CITY OF ALBUQUERQUE

April 23, 2020

Re: Highlands Market Parking Lot
1111 Central Ave. NE
Traffic Circulation Layout
Architect's Stamp 01-07-2020 (K15D034D)

Based upon the information provided in your submittal received 04-22-2020, the above referenced plan cannot be approved for Building Permit until the following comments are addressed:

05 TYPICAL ACCESSIBLE PARKING STALL

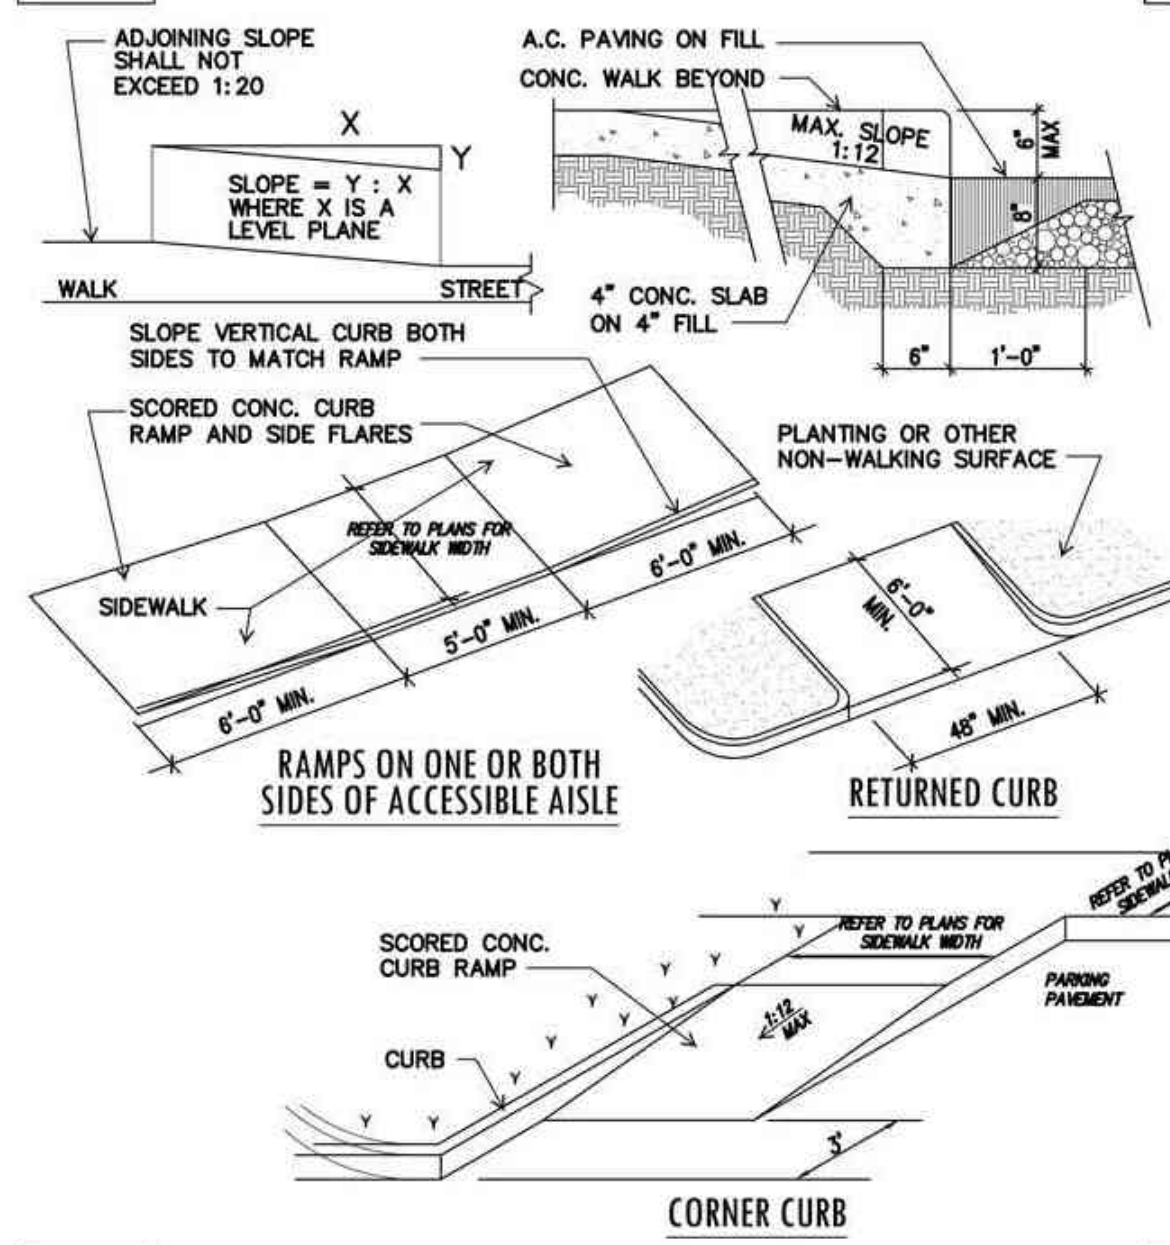
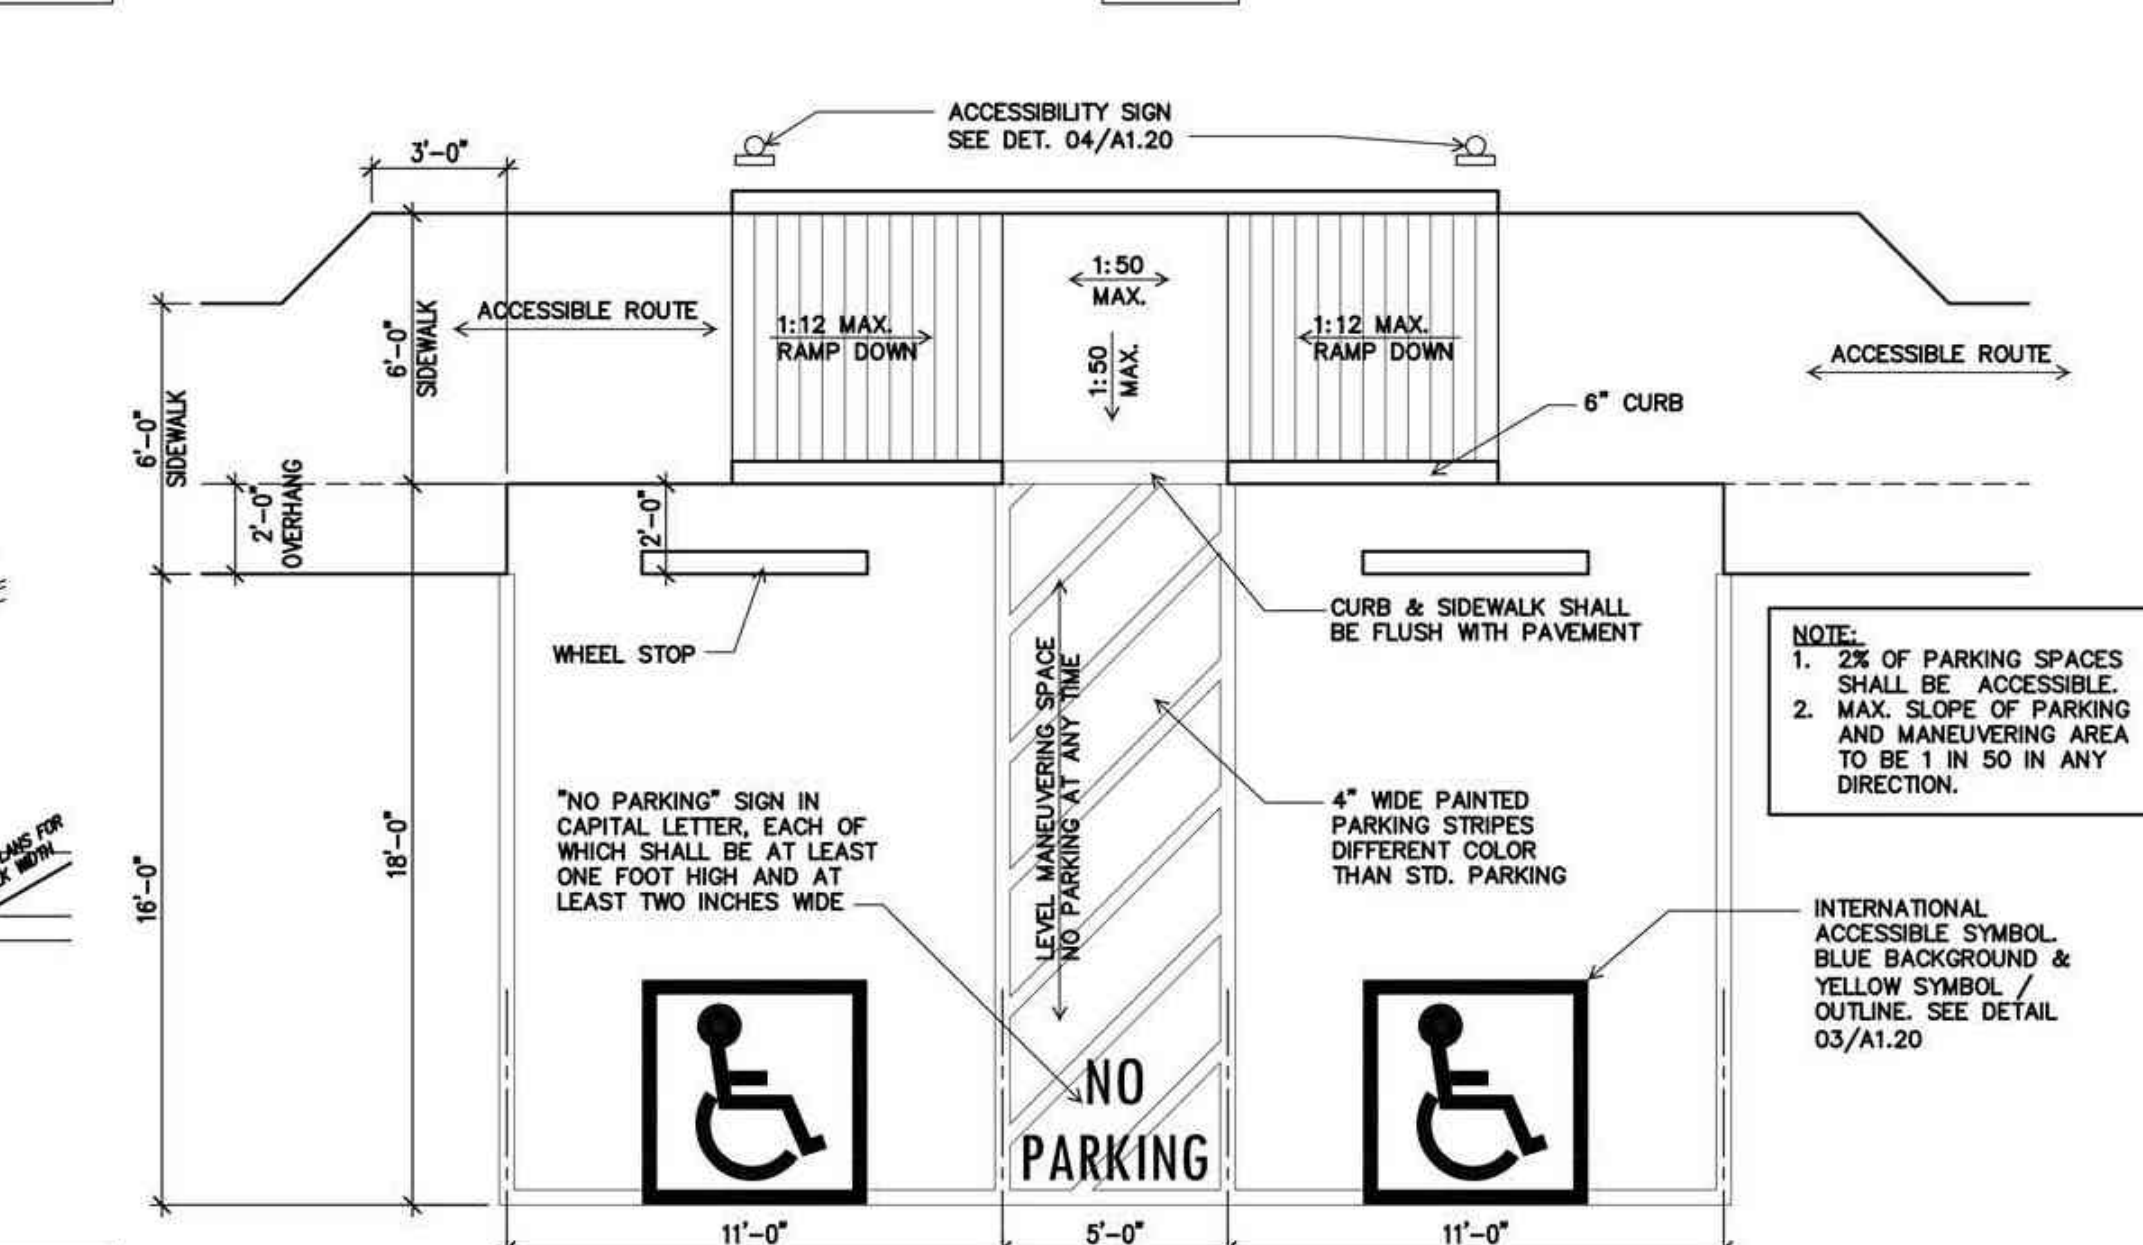
1. Please coordinate all parking calculations with Zoning and list the number of parking spaces required by the zoning as well as the proposed number of parking spaces including bicycle and motorcycle parking (this includes ADA accessible parking stalls). The ADA parking stall will need to be address at the present moment to obtain project approval (**If you need to discuss this comment please contact me**) and the ramp opening must be 6ft wide (And any other required parking must be provided at present time).

2. All ADA accessible ramps within public property must be provided and a detail with appropriate slopes and dimension be shown on this project.
3. Identify all proposed infrastructure within public street and either reference City standard drawing number or provide a detail. **Since you have provided a note specifying that all improvements located in the Right of Way will be included on a Work Order, a condition for Final C.O. approval that work order is completed and approved of this segment of proposed plan.**
